09032
19 October 2010

**MODIFICATION TO MAJOR PROJECT MP09_0156
DARLING WALK FIT-OUT OF COMMERCIAL TENANCY AND ERECTION OF SIGNAGE**

Level B2

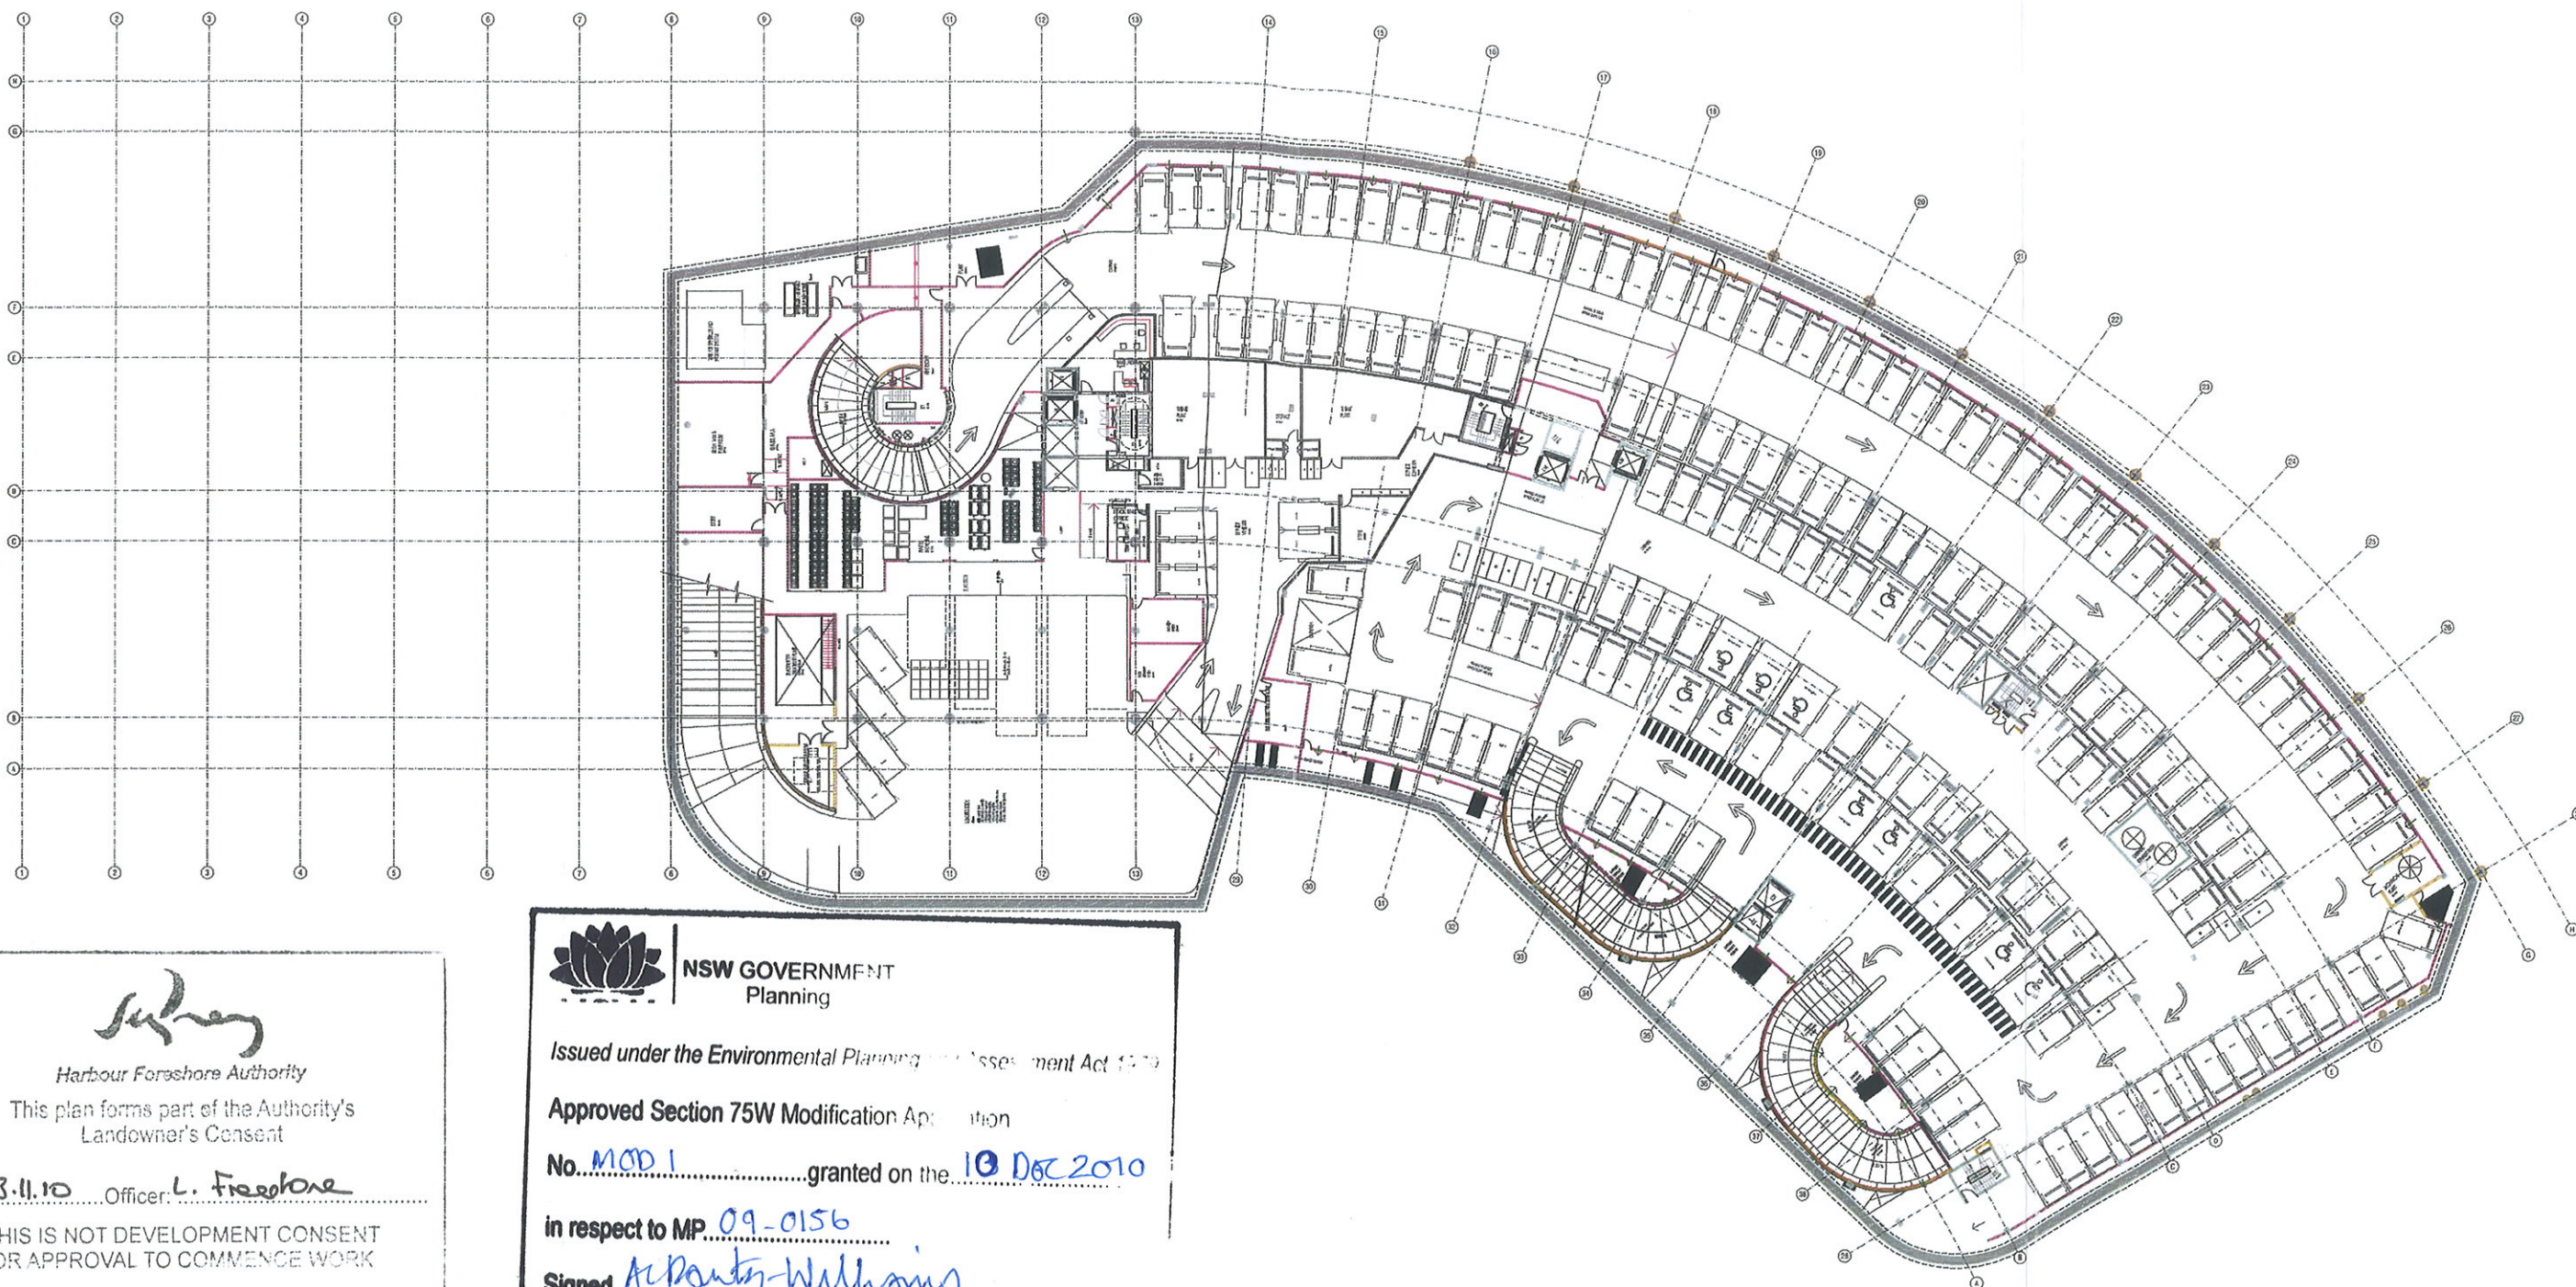
This modification application seeks to include the above drawings into the approved list of plans. The plans relate to the fit-out of the mail room, dock masters room and the uninterruptible power supply (UPS) room. The location of the rooms within Basement Level 2 was approved as part of the Concept Plan for the base building. The fit-out works include:

- *mail room* - installation of joinery including pigeon holes and desks, as well as power and communications infrastructure;
- *dock masters room* – installation of joinery as well as power and communications infrastructure; and
- *UPS rooms* - installation of UPS equipment and air conditioning units.

It is proposed to amend the drawing references in Condition A2 of Schedule 2 as set out below. Words proposed to be inserted are shown in ***bold italics***. All architectural drawings have been prepared by Bovis Lend Lease.

Drawing No.	Revision	Name of Plan	Date
<i>08013-DW-DA-B2</i>	<i>B</i>	<i>Level B2</i>	<i>23.11.2009</i>
